DEVELOPMENT REVIEW BOARD
SUPPLEMENTAL SUBMITTAL

PROJECT NO. 2020-003461 (17EPC-40043)
Application No. SI-2020-00052

SUBMITTAL DESCRIPTION: Revised plans, Approved Fire One, and response to comments

RE: Project #2020-003461/SI-2020-00052 (17EPC-40043), Taylor Ranch Housing
Site Plan-EPC Major Amendment

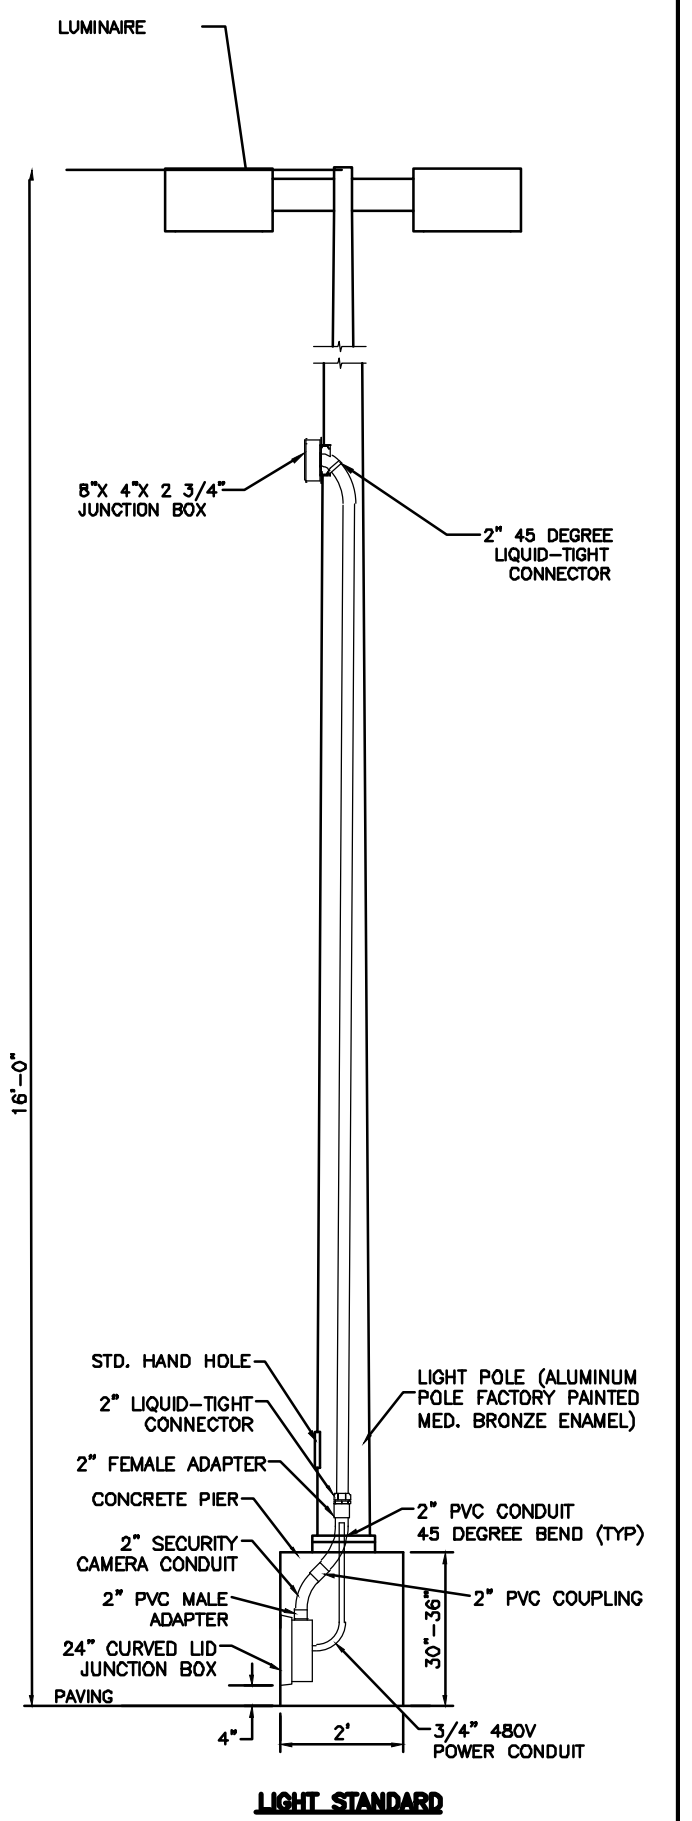
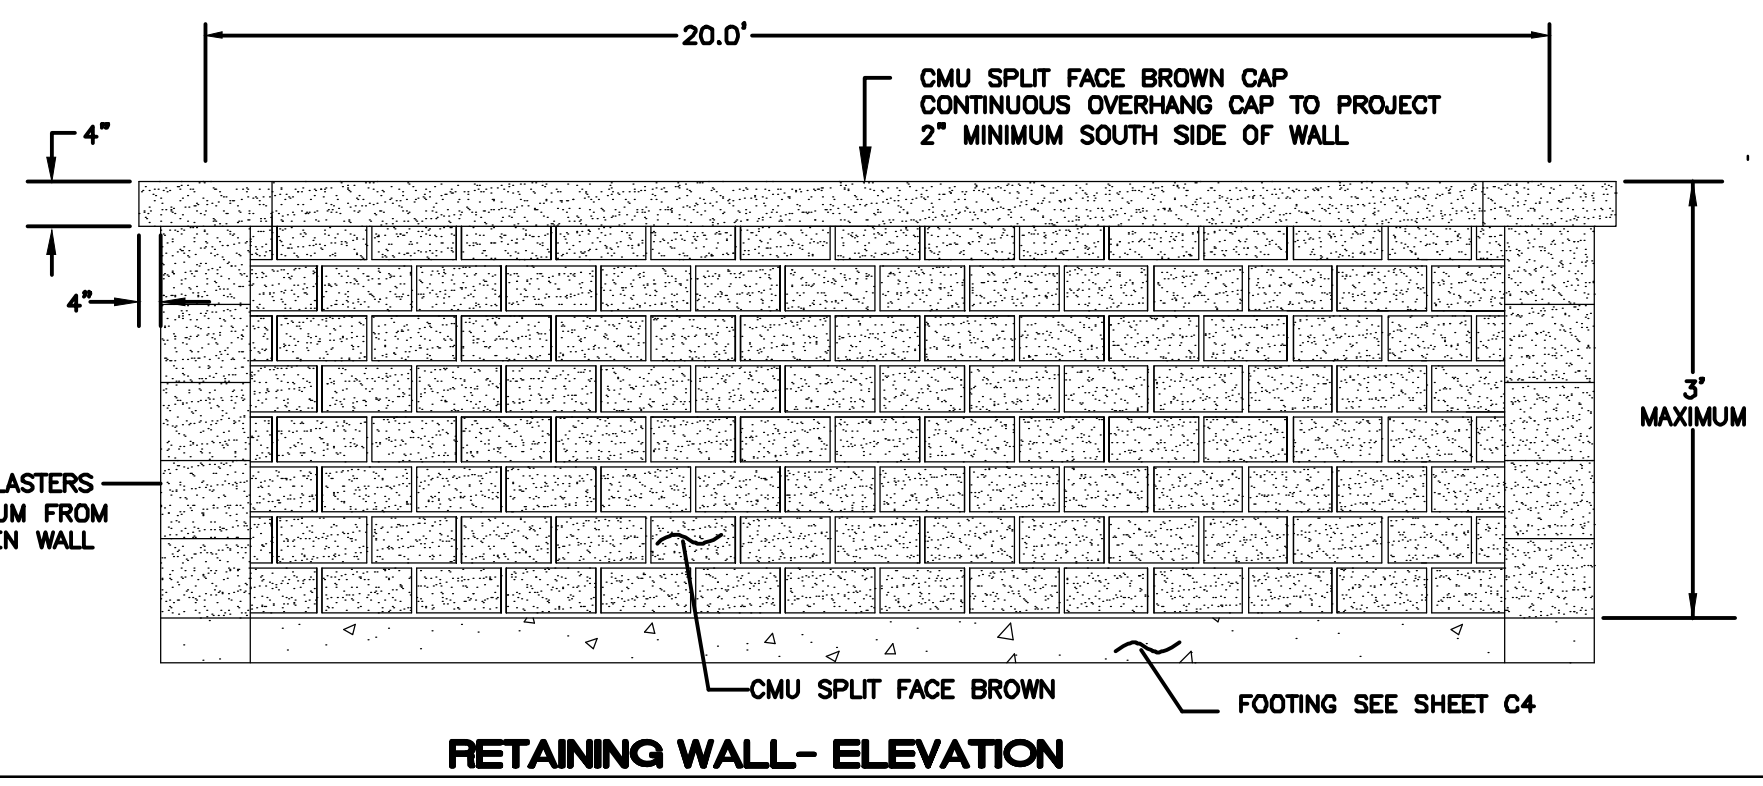
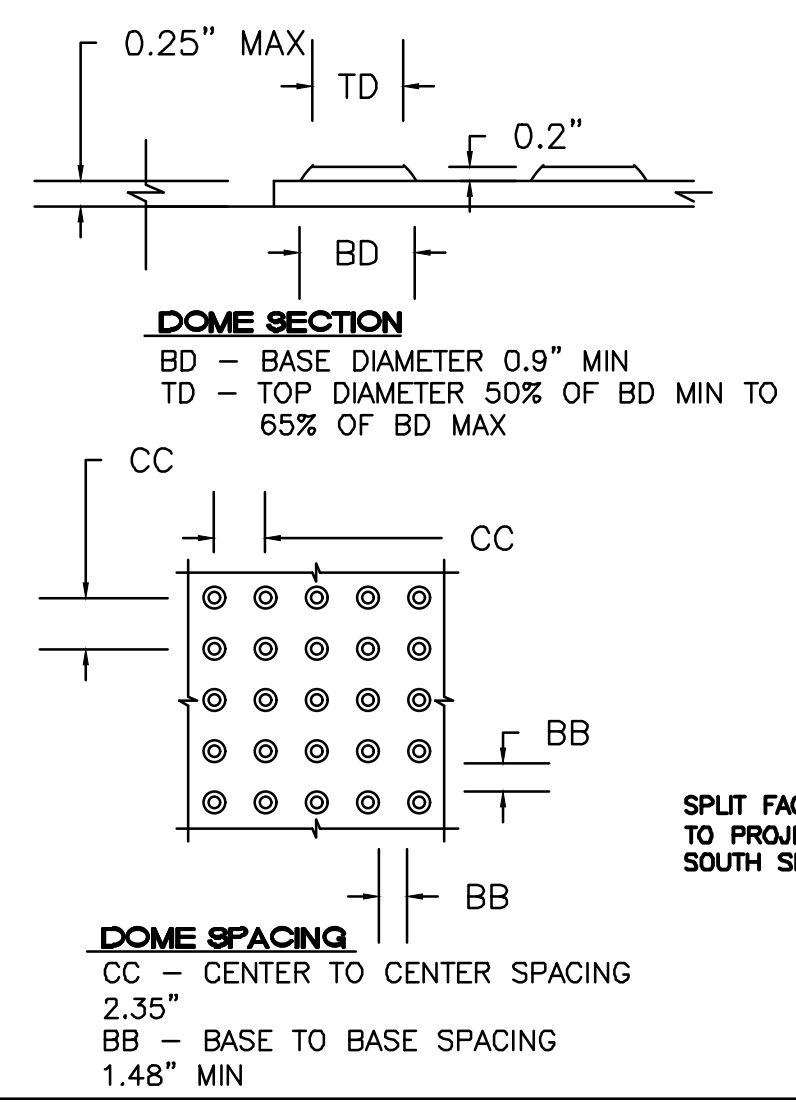
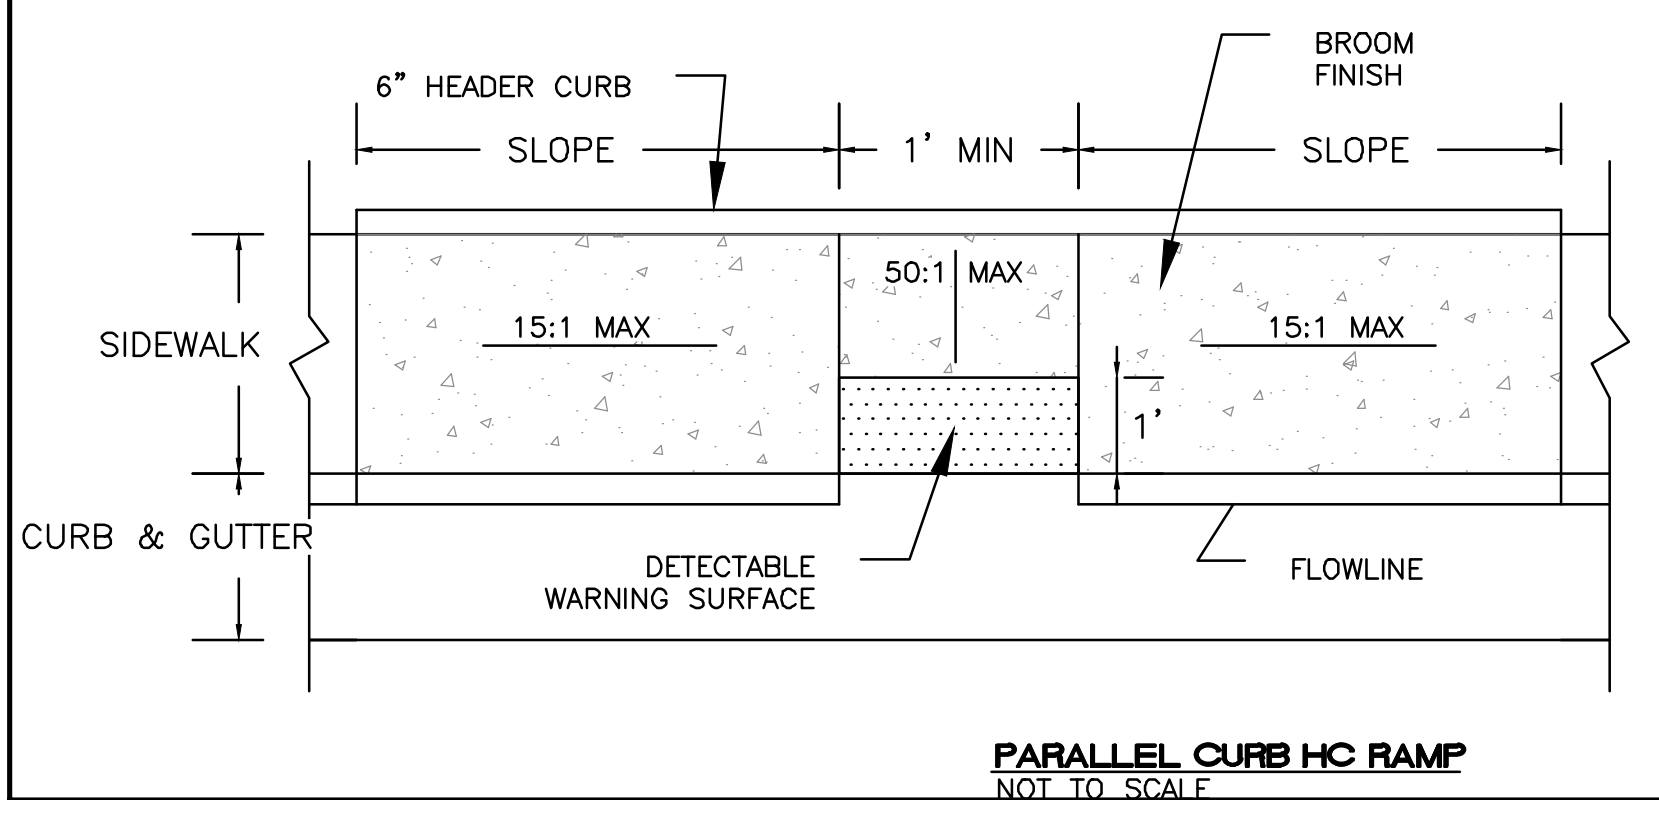
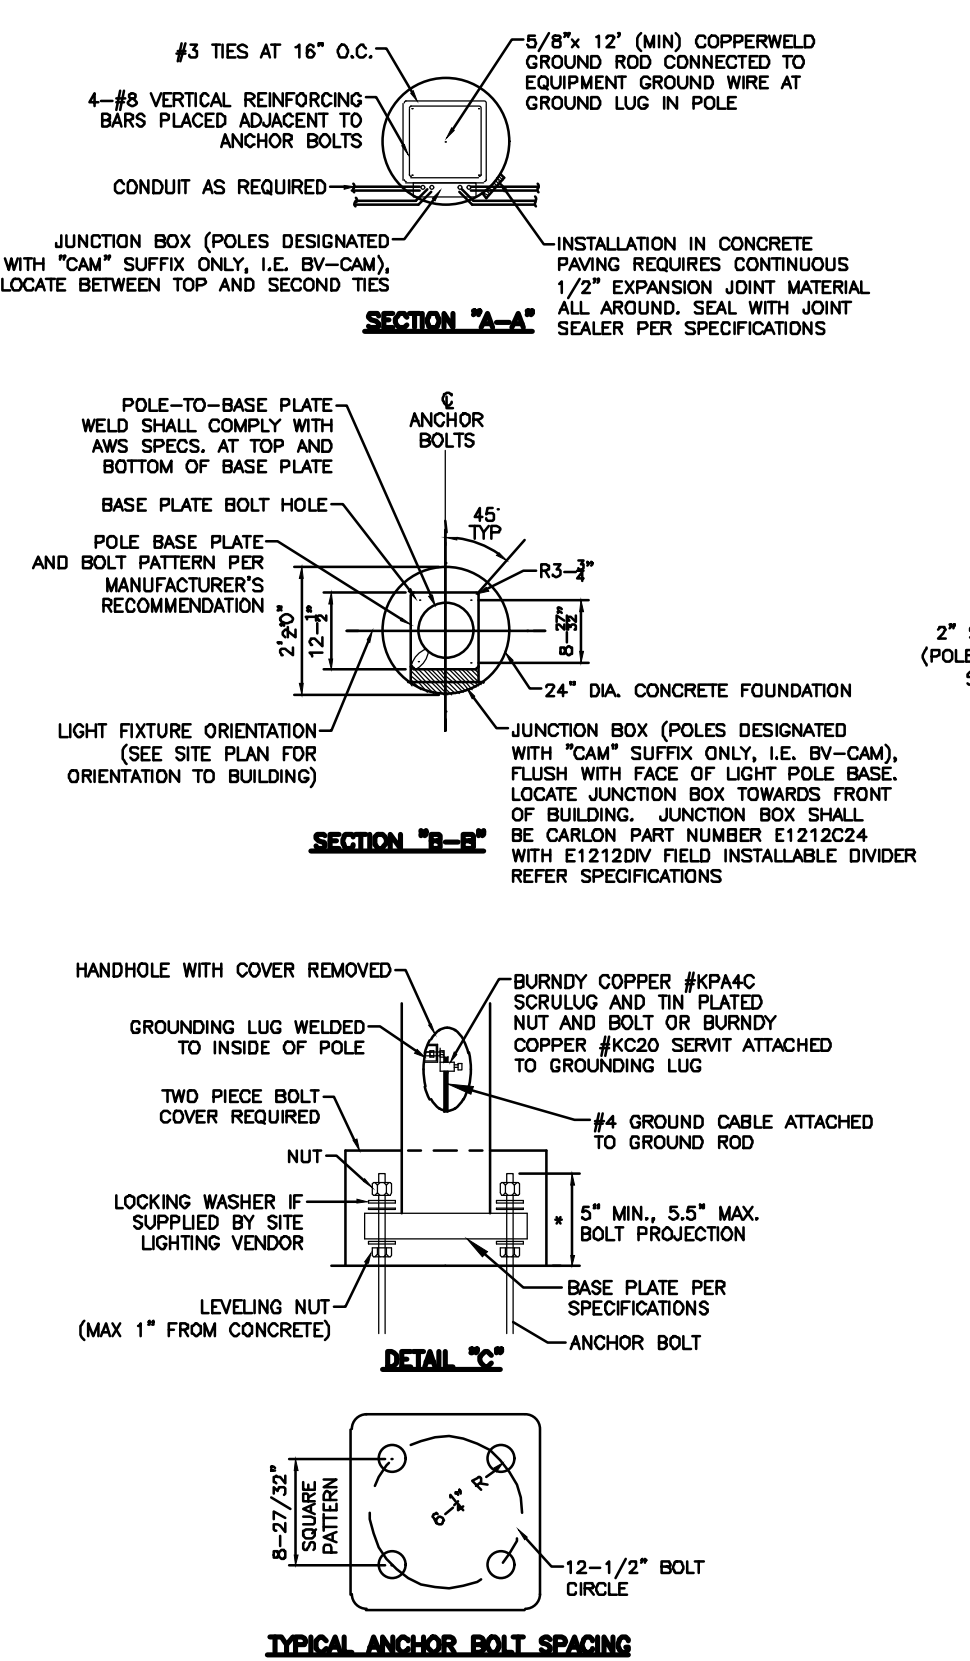
5. Provide further details for bollards at Montano Road. Need spacing and embedment details and details that were provided were not legible. and landscape pavers. Coordinate with Fire Marshall.

9. Show both types of curb ramp details called out on the plan. One is uni-directional; the other is a parallel curb ramp in front of the accessory buildings.

10. Condition 9A- unmet: A standard light pole detail was not provided. The detail on Sheet C5 is only for lights with "pole mounted cameras", which are not referenced on the main site plan. This detail should be removed.

Note: the top height of this light pole is not dimensioned or scaled, but clearly exceeds the allowable height of 20 feet.

Response: Updated call-out #22 to include minimum 3-ft spacing maximum 5-ft spacing between bollards. Bollard is a minimum Type III type bollard. Landscape pavers for fire access included detail on sheet C6 and meets fire marshal requirements.

Response: Added detail to C-5.

Response: Detailed updated.

Sheet Number:
LP-02

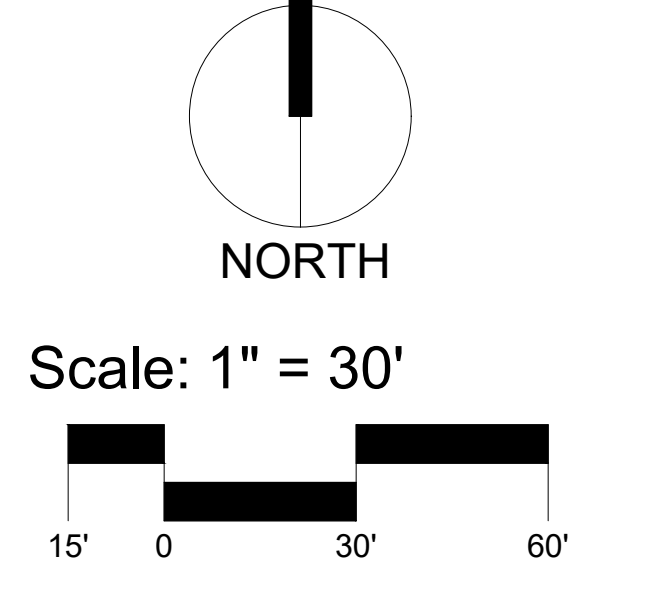
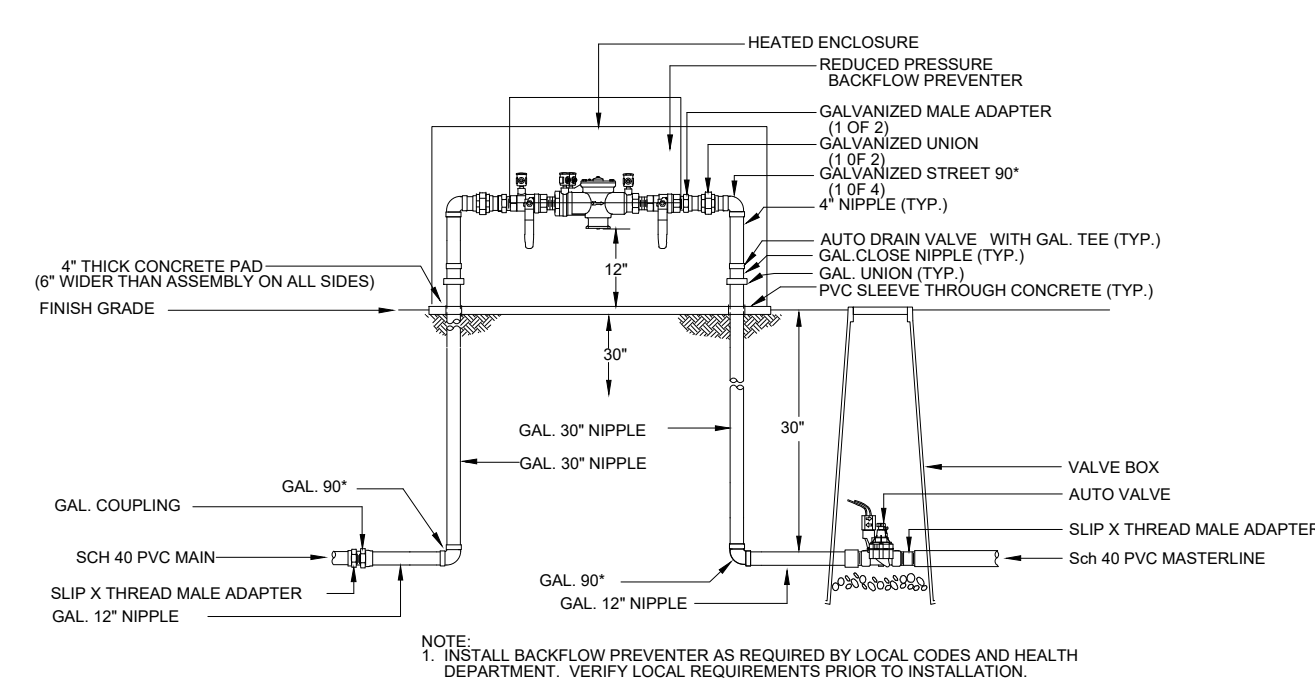
3. Condition 6A- unmet: Shade trees shall be provided along required pedestrian walkway [IDO Section 14-16-5-3(D)(3)(b)(2)(a)] along the project site's western boundary. An on-site pedestrian walkway that connects to the sidewalk is required pursuant to.

8. Condition 7C- unmet: The northern landscape buffer width shall be labeled consistent with the width shown on Sheet C-1. It's 15' on Sheet C-1 and 18' on Sheet LS-1.

12. Condition 12D-unmet: The same number for building square footage shall be used on Sheet C-1 and on the landscaping plan.

Response: Required shade trees details on the plan and placed along pedestrian walkways where possible.

Response: Landscape plan updated.

Response: Landscape plan updated.
